Bramford to Twinstead Reinforcement

Document 8.5.3.2: Applicant's Comments on Essex County Council and Braintree District Council Local Impact Report

Final Issue A
October 2023

Planning Inspectorate Reference: EN020002

ELEVATION - A  
 SCALE 1:150

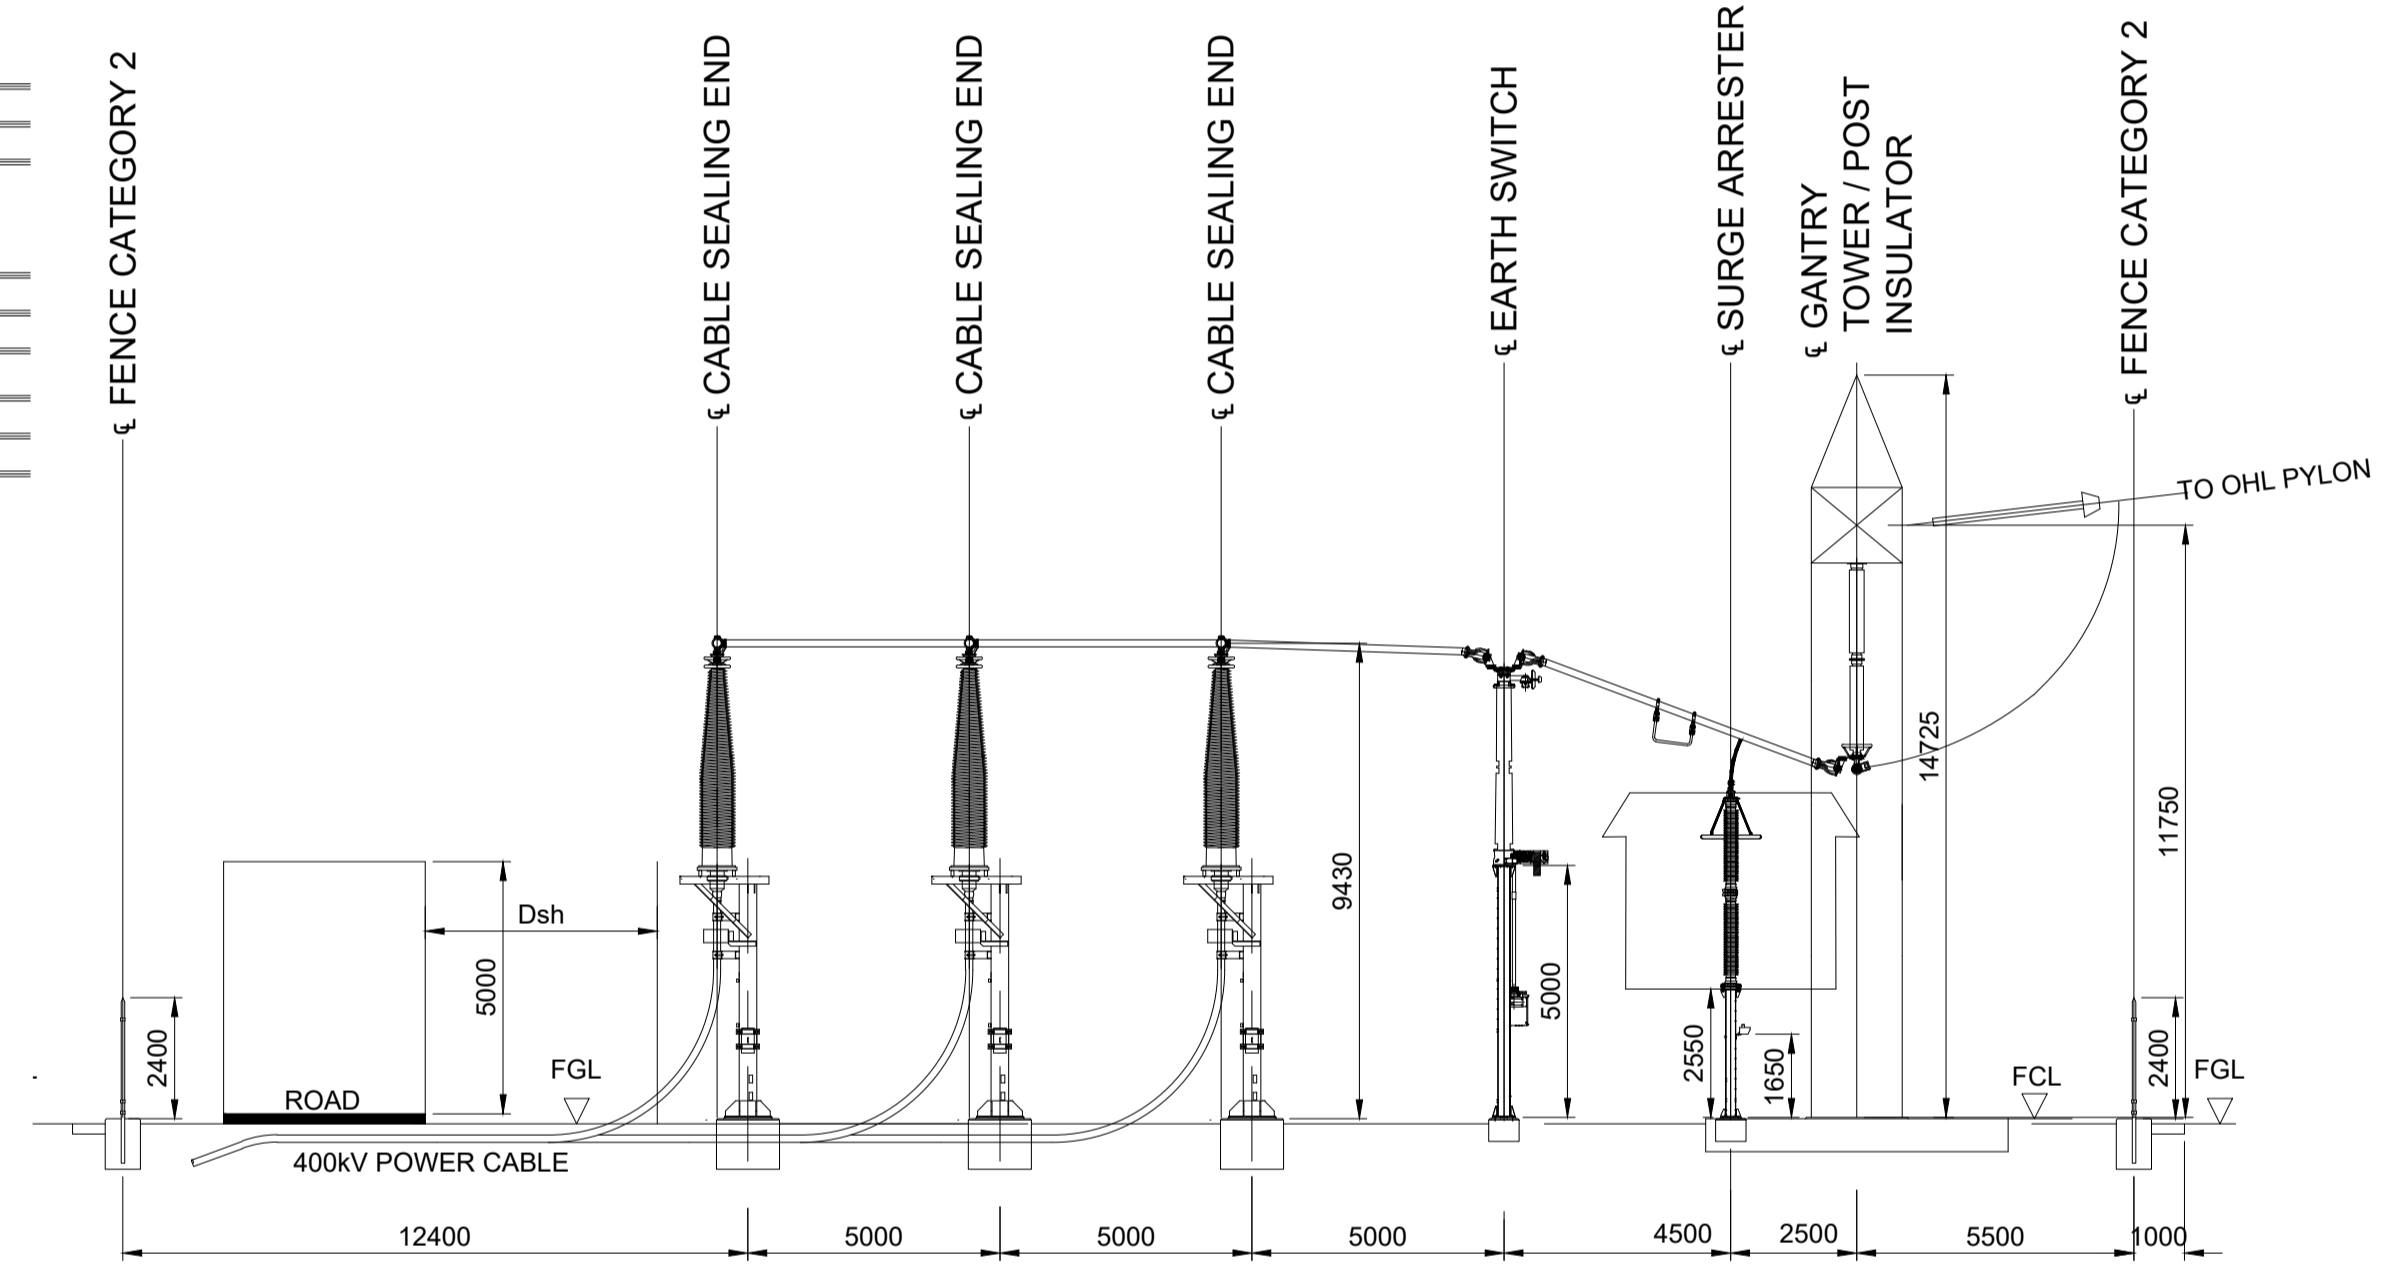
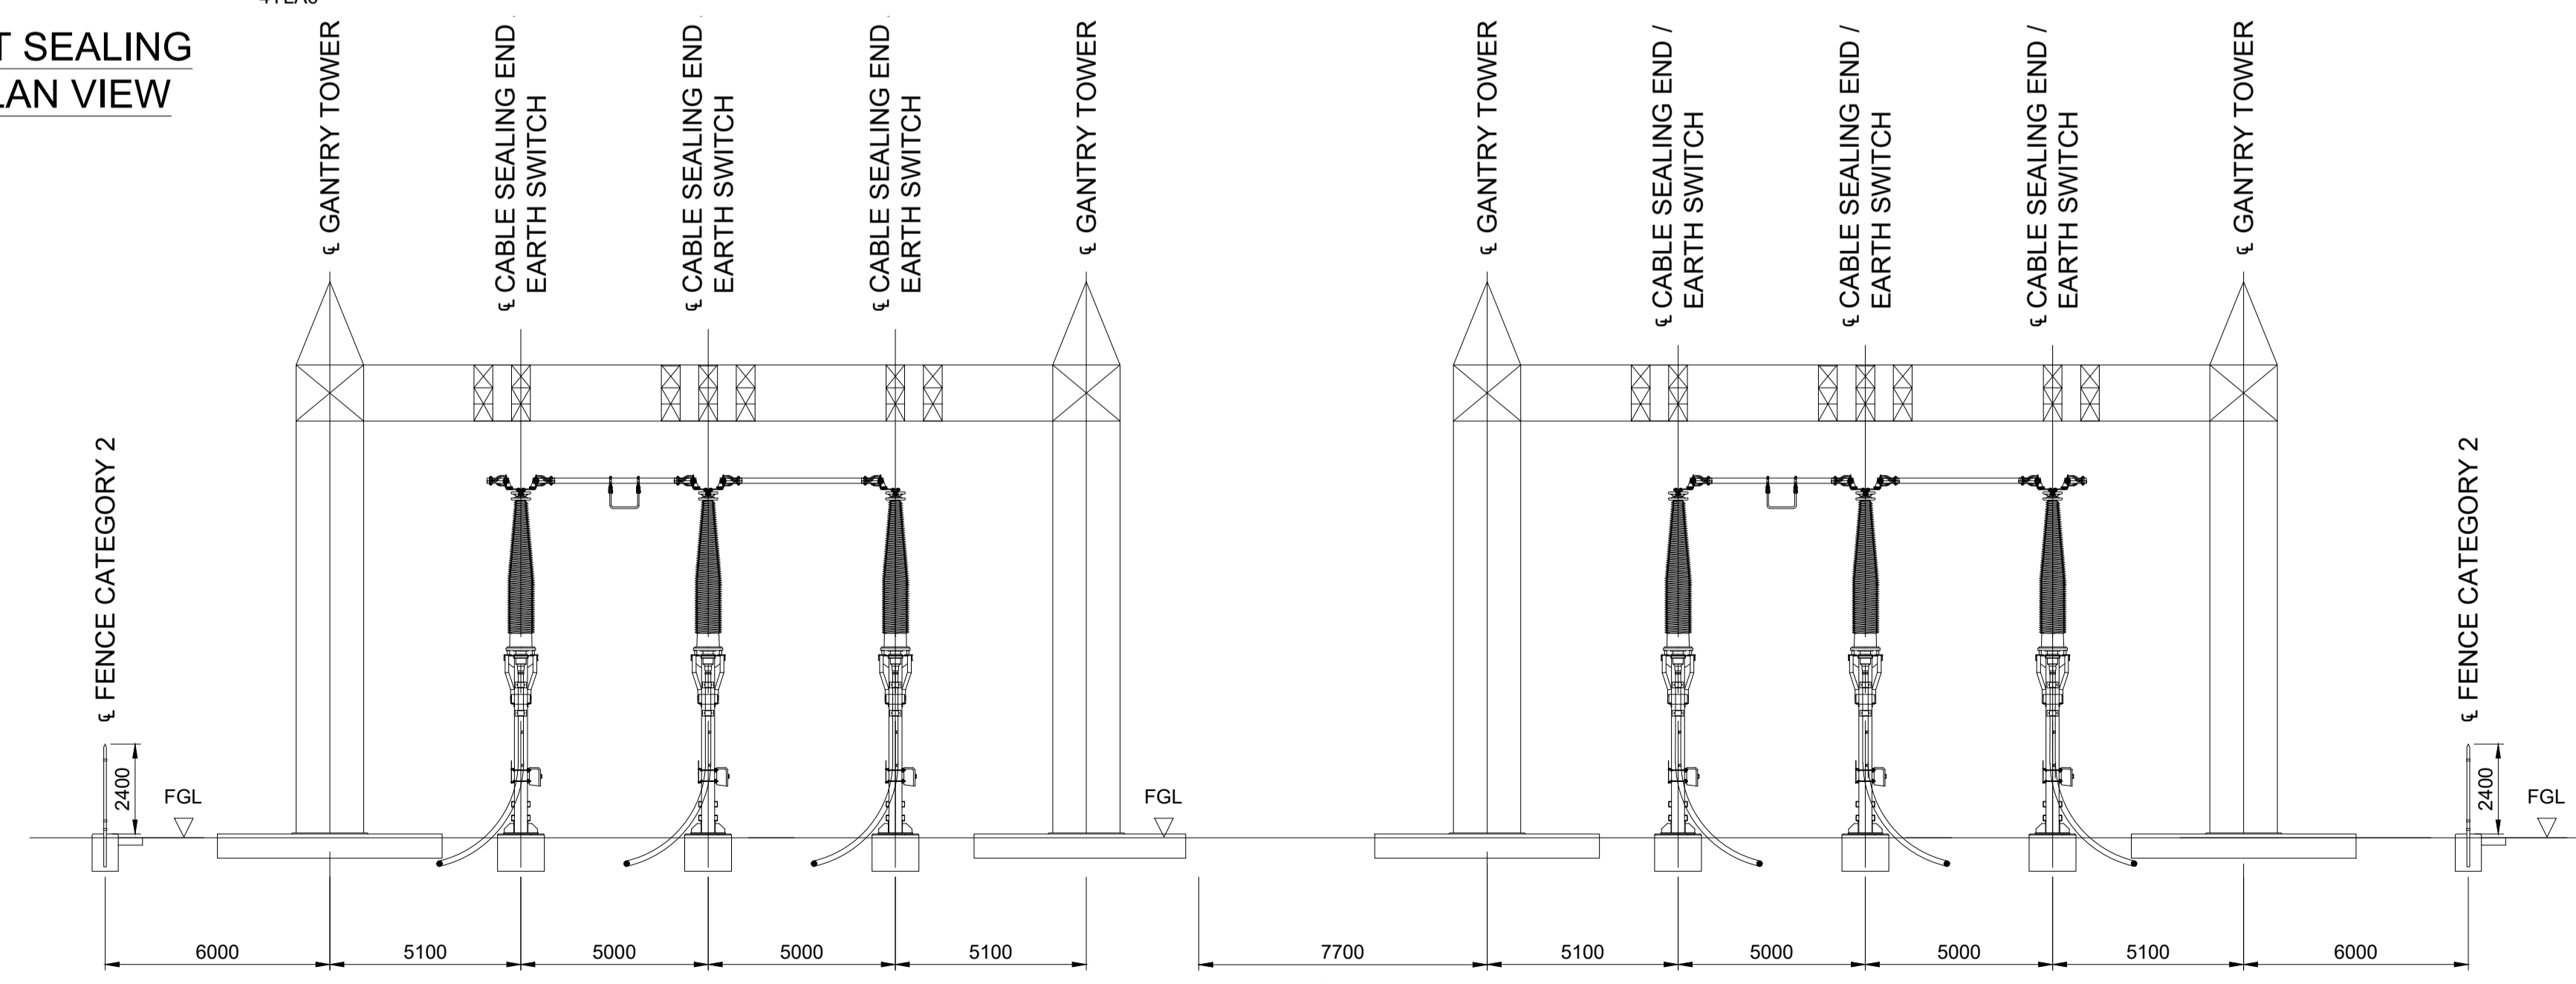
7.5.5	Construction phase impacts – Stour Valley West CSE compound (visual)	The Stour Valley West Cable Sealing End (CSE) compound inserts a structure up to 11.7m high into the landscape close to a PRoW. From the viewpoint Year 1 photomontage (G07 View from PRoW near Mabb's Corner) the extent and nature of the planting, designed to mitigate these impacts, is unclear. Whilst removal of the 132kV cable line gives substantial landscape and visual benefits, the new structure creates an adverse impact during construction and Year 1.	<p>Locations of planting for Stour Valley West CSE compound are shown in the LEMP on Sheet 28 at Appendix B Vegetation Reinstatement Plan (document 7.8.2 (B)) and planting schedules are provided at Appendix C Planting Schedules [APP-185]. Based on the average growth rates set out in Table 3.1 in Photomontages [PDA-001] it is assumed that the native trees would achieve heights up to 7.7m after 15 years. However, views from the south would remain open due to the location of the underground cables. The effects of this are shown in photomontage 34B at G-07 presented in Appendix 3 Photomontages [APP-065].</p> <p>Environmental Statement Chapter 6: ES Chapter 6: Landscape and Visual [APP-074] summarises the results of the landscape and visual impact assessment. As with any large construction project there would be some significant adverse effects during construction and in Year 1 before the vegetation establishes. However, there would also be some significant beneficial landscape and visual effects on the Stour Valley as stated in Table 6.5 of ES Chapter 6: Landscape and Visual [APP-074]. This is due to the removal of sections of the 132kV and the 400kV overhead lines in association with the proposed 400kV underground cables.</p>
